# Walterstown 110 kV Substation

Response to Submissions (Case reference: ACP-324031-26)

April 2026

**Document reference:** PL1 | 229101684-MMD-01-XX-RP-C-007

## Contiguous Site Elevations

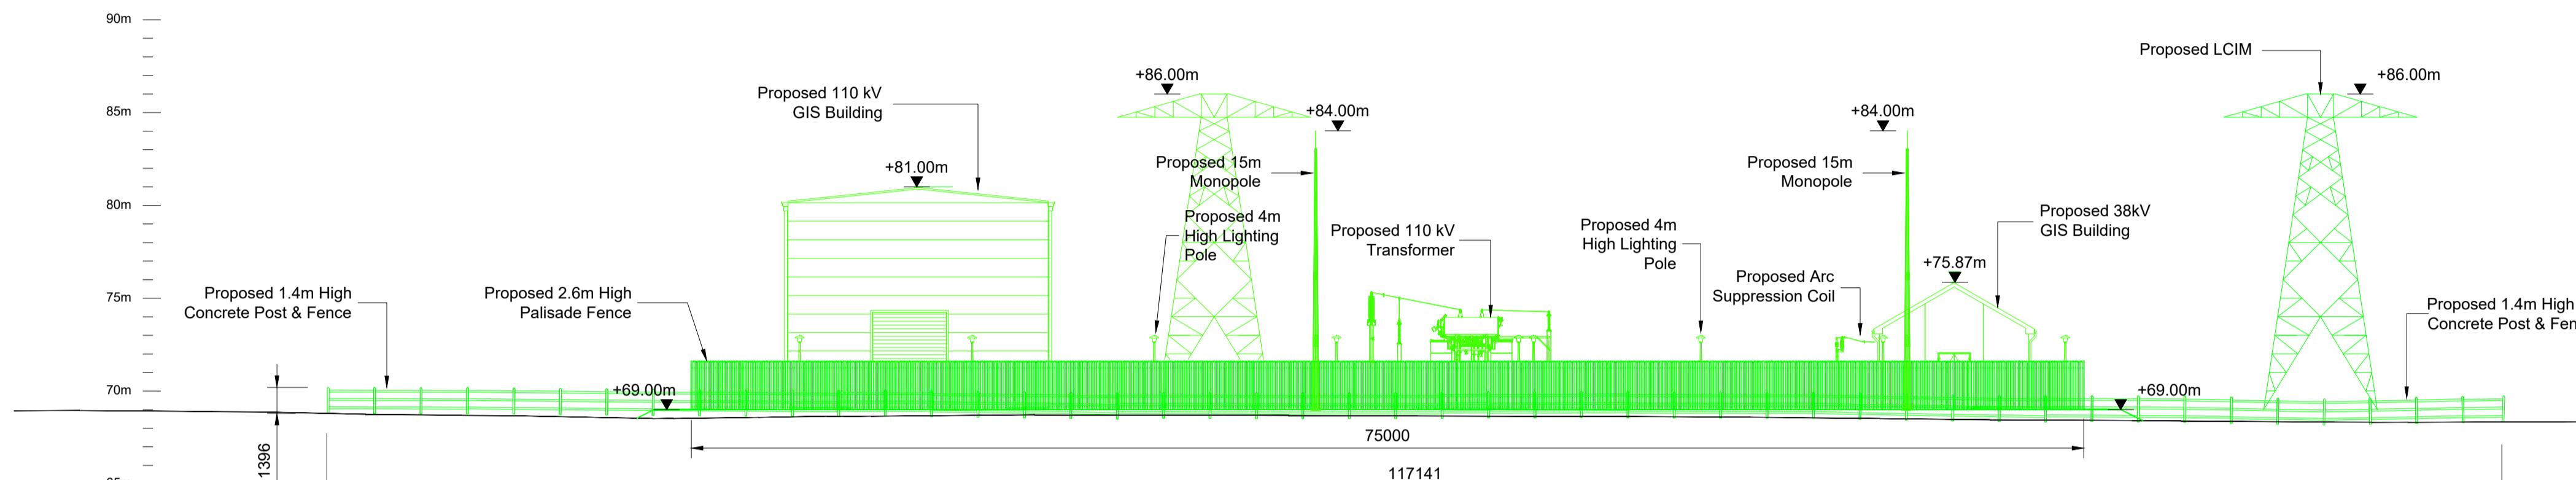
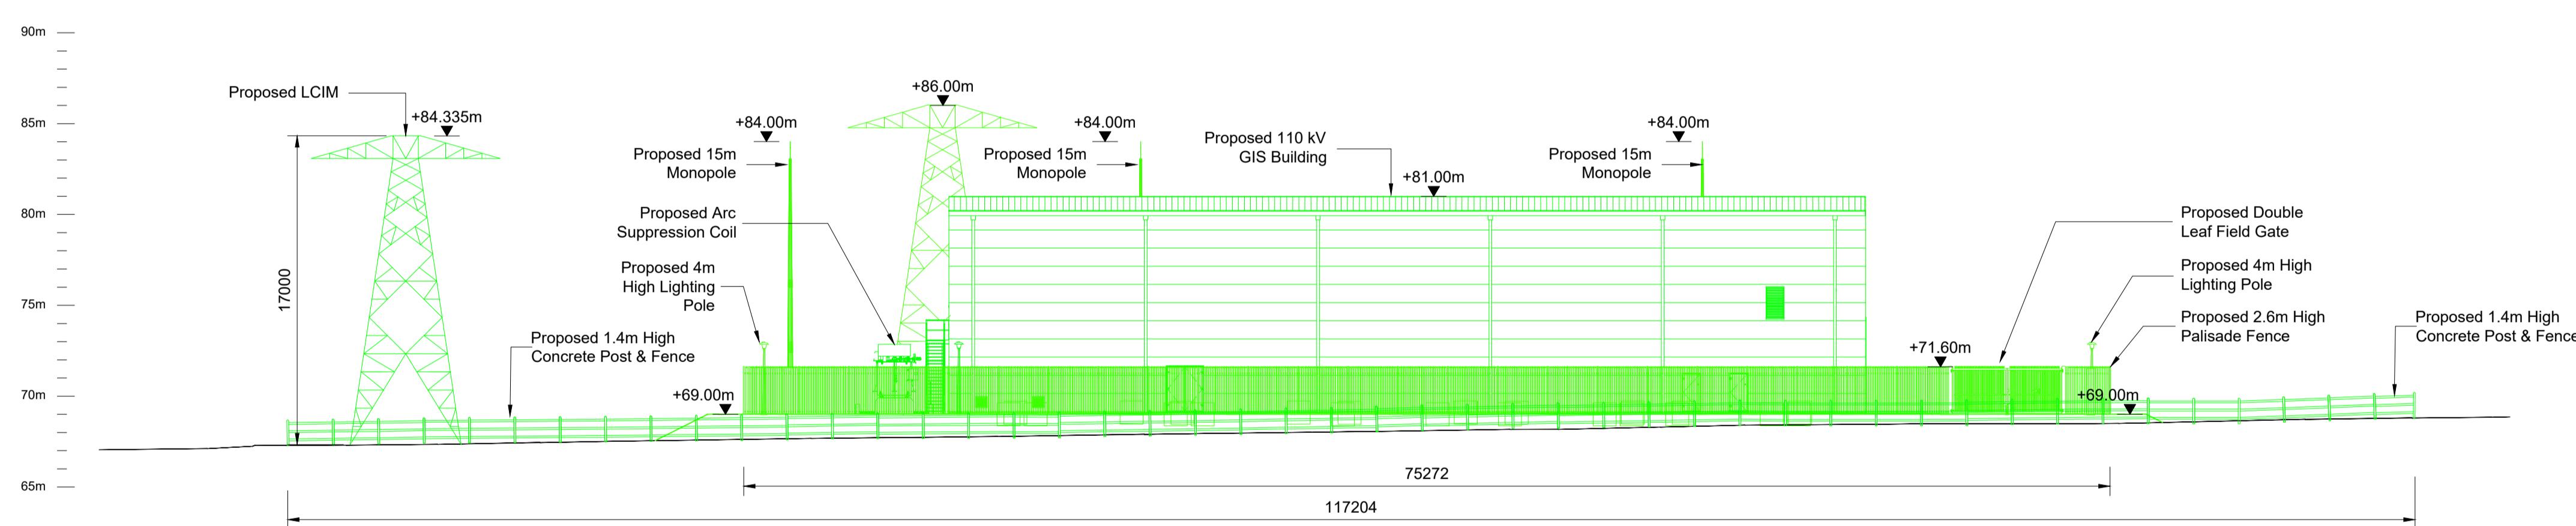
In the interest of clarity, it must be noted that one submission refers to LCIM towers as being in the order of 84-86m in height. As stated in the statutory notices, planning drawings and PECR, the proposed LCIMs will be approximately 17m in height. This is also illustrated within the Contiguous Site Elevation drawings (Drawing Number 229101684-MMD-00-XX-DR-C-0130).

Drawing file: Planning Drawings / LD_WLTSTWN_LMP_1.0 Landscaping Mitigation Plan.pdf

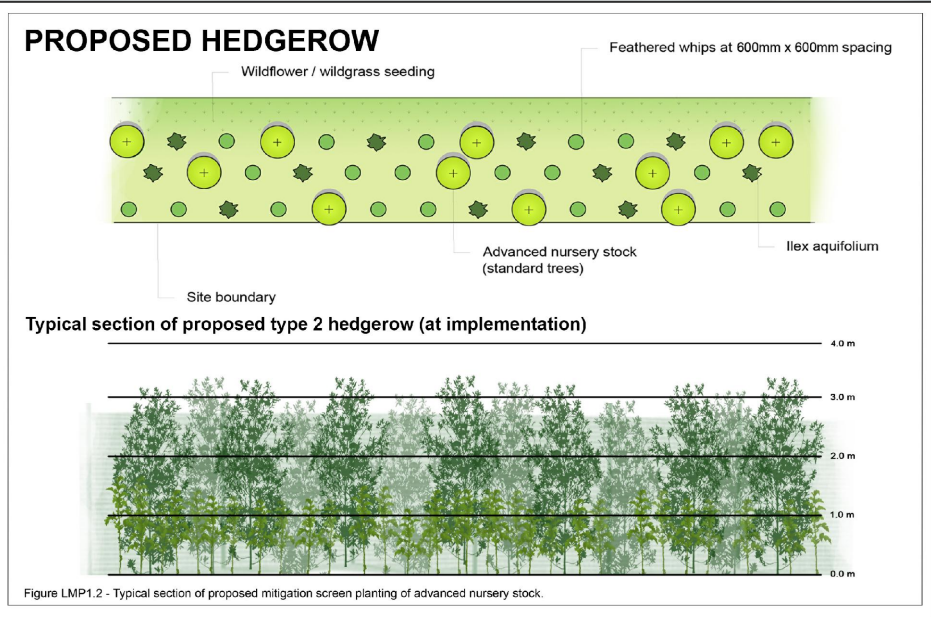
In the above regard, submissions raise concerns relating to the visual impact of the proposed substation and associated Line Cable Interface Masts (LCIMs), including their scale and proximity to nearby residential properties.

In the above regard, the presence of existing vegetation (established vegetated field boundaries and treelines) which will be largely retained and supplemented by substantial native woodland and hedgerow planting, as illustrated in the Landscape Mitigation Plan (Drawing Number LD\_WLTSTWN\_LMP\_1.0), will successfully screen the proposed development, once planting has been established. This planting will provide effective screening of the substation compound and associated infrastructure in medium to long-term views. The Landscape and Visual Impact Assessment (LVIA) concludes that landscape and visual effects associated with the Proposed Development will be localised, limited in magnitude and readily mitigated, particularly once proposed planting becomes established (as depicted in VP3a and VP3b *Established Mitigation* photomontages, Appendix 12.1 of the PECR). Beyond approximately 500m from the site boundary, effects are generally imperceptible.
